Planning Application No: 3/2024/0075

Proposal: Proposed demolition of conservatory and construction of two-storey extension to side. Demolition of utility room and construction of single-storey extension to rear. Conversion, extension and roof lift of attached WC store and garage to single-storey bedroom/office.

Location: Lower House Farm Settle Lane Paythorne BB7 4JD

The submitted documents and plans have been reviewed and the following comments are made:

6832 -P03

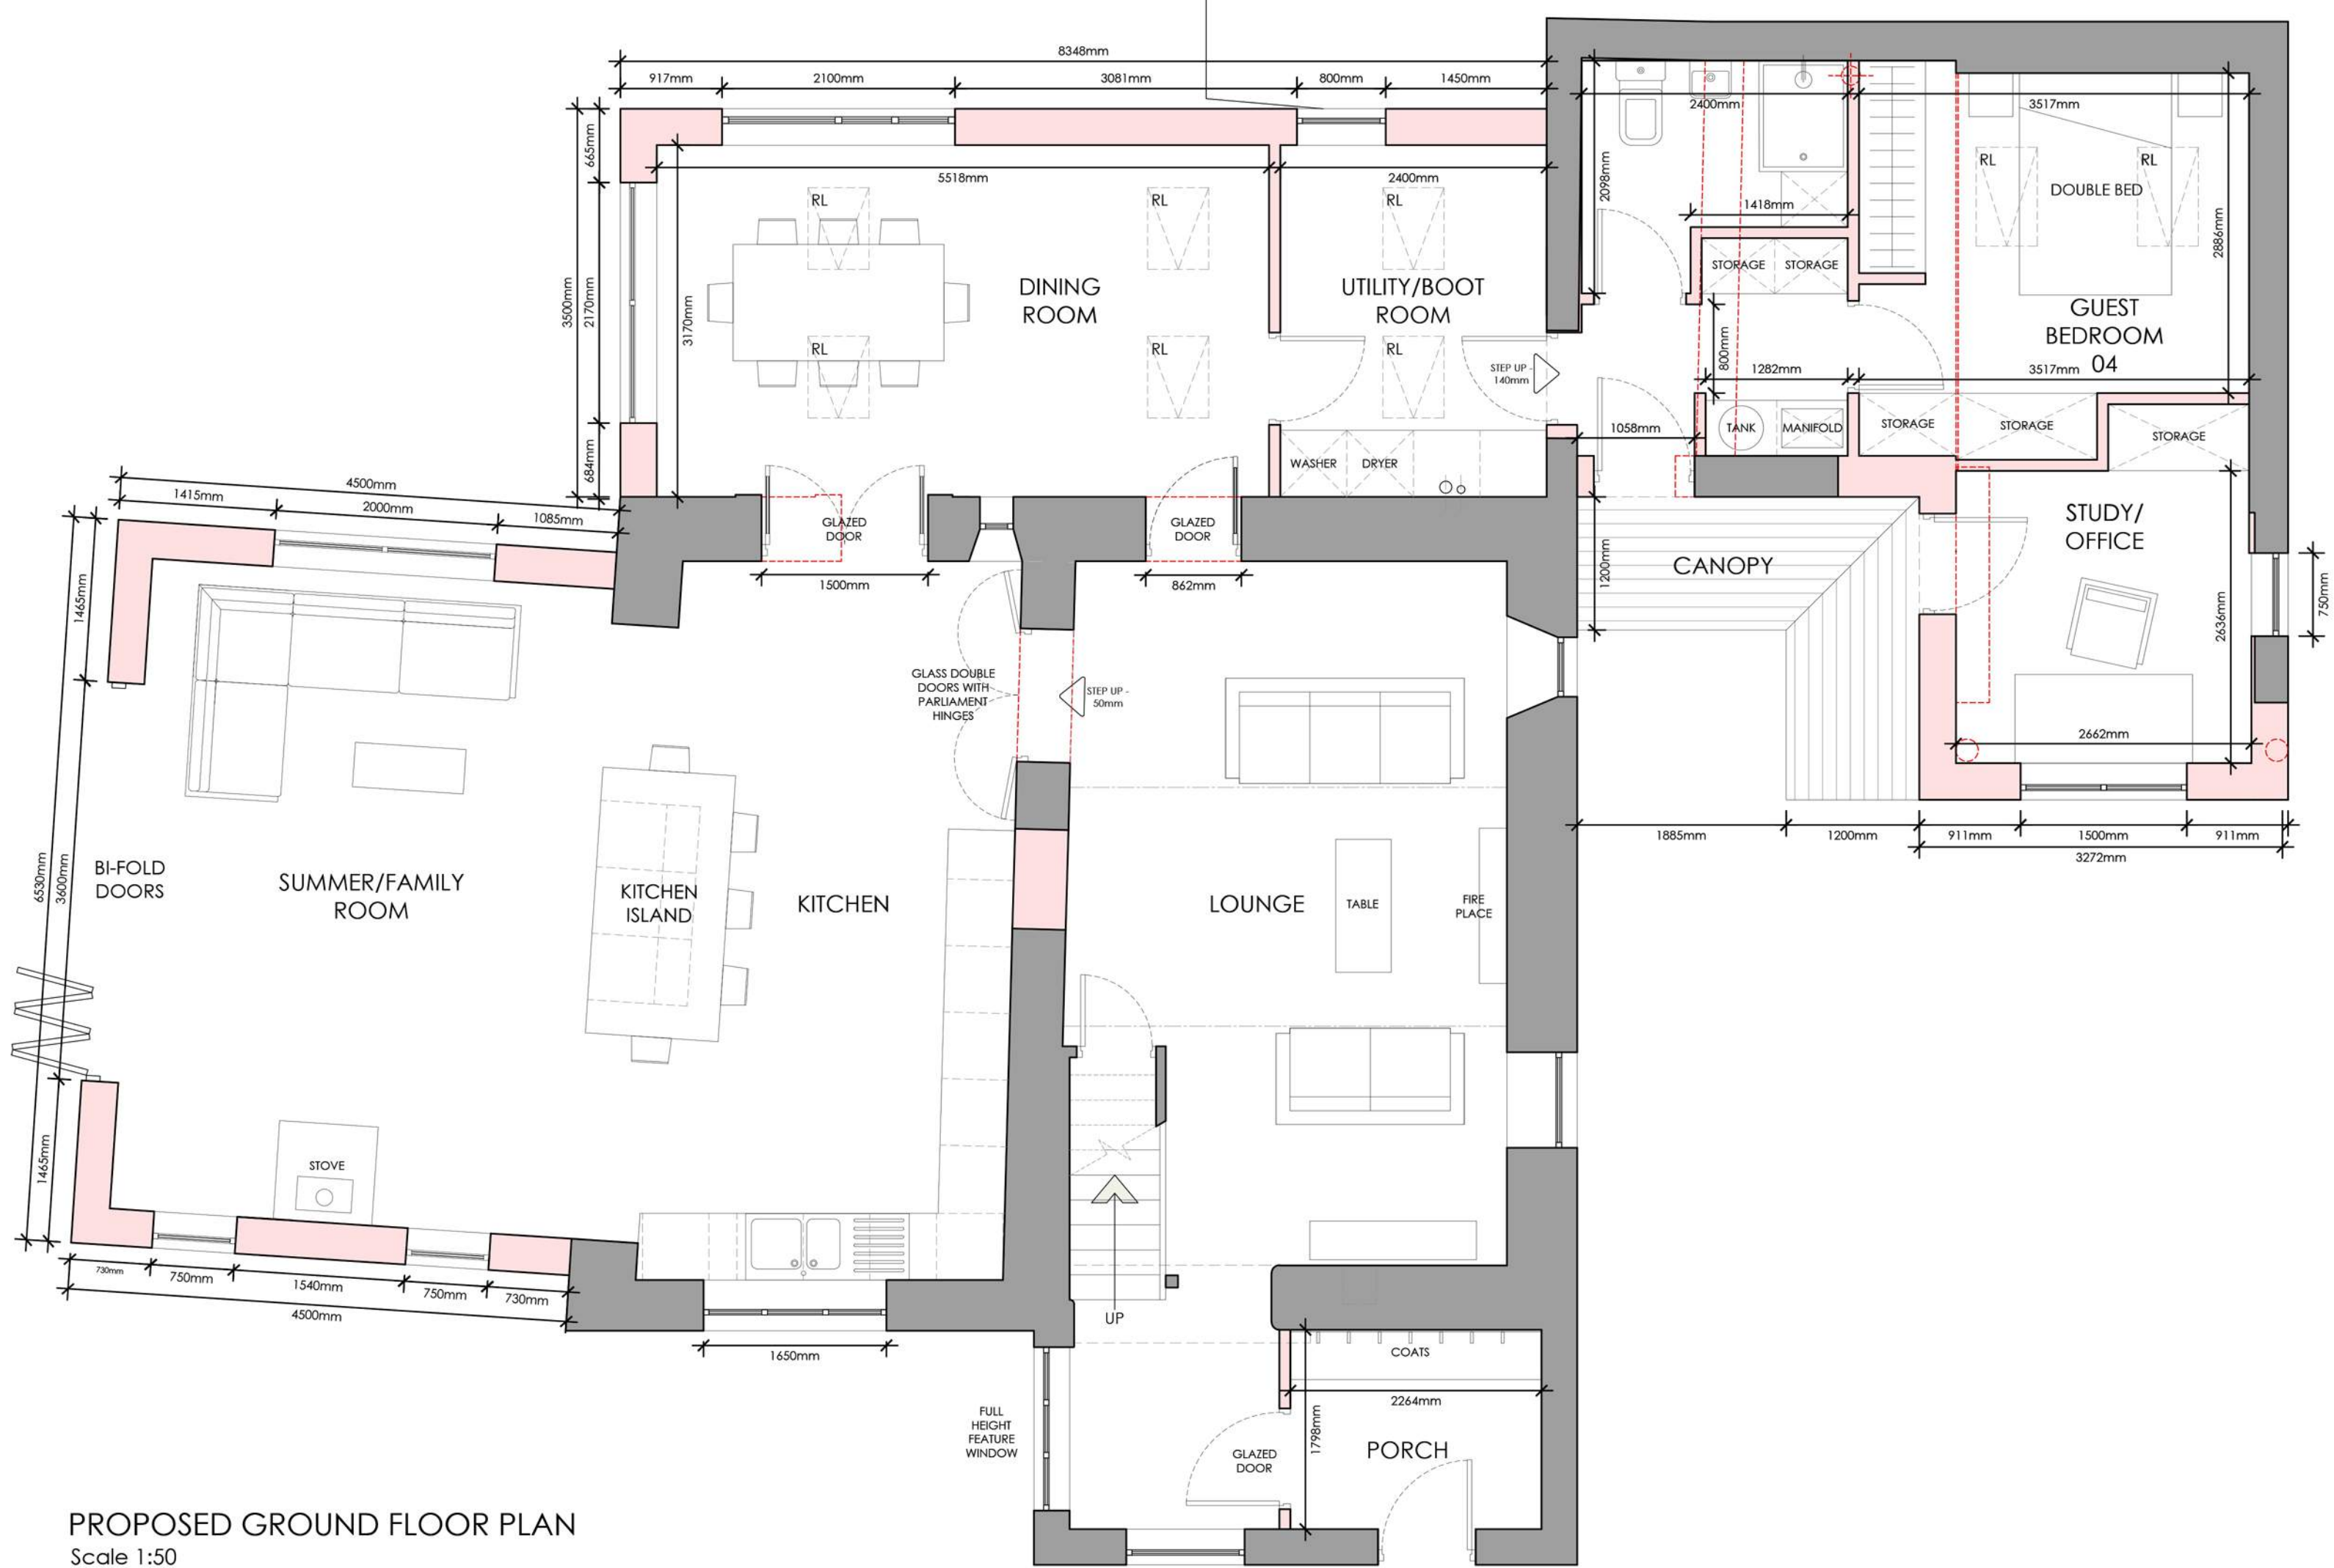
Whilst there is no objection to the principle of the development, there is an increase in the number of bedrooms with this proposal from the existing 2 to a proposed 4, therefore, parking standards require 3 parking spaces for this size of proposal. These should be available within the curtilage of the property.
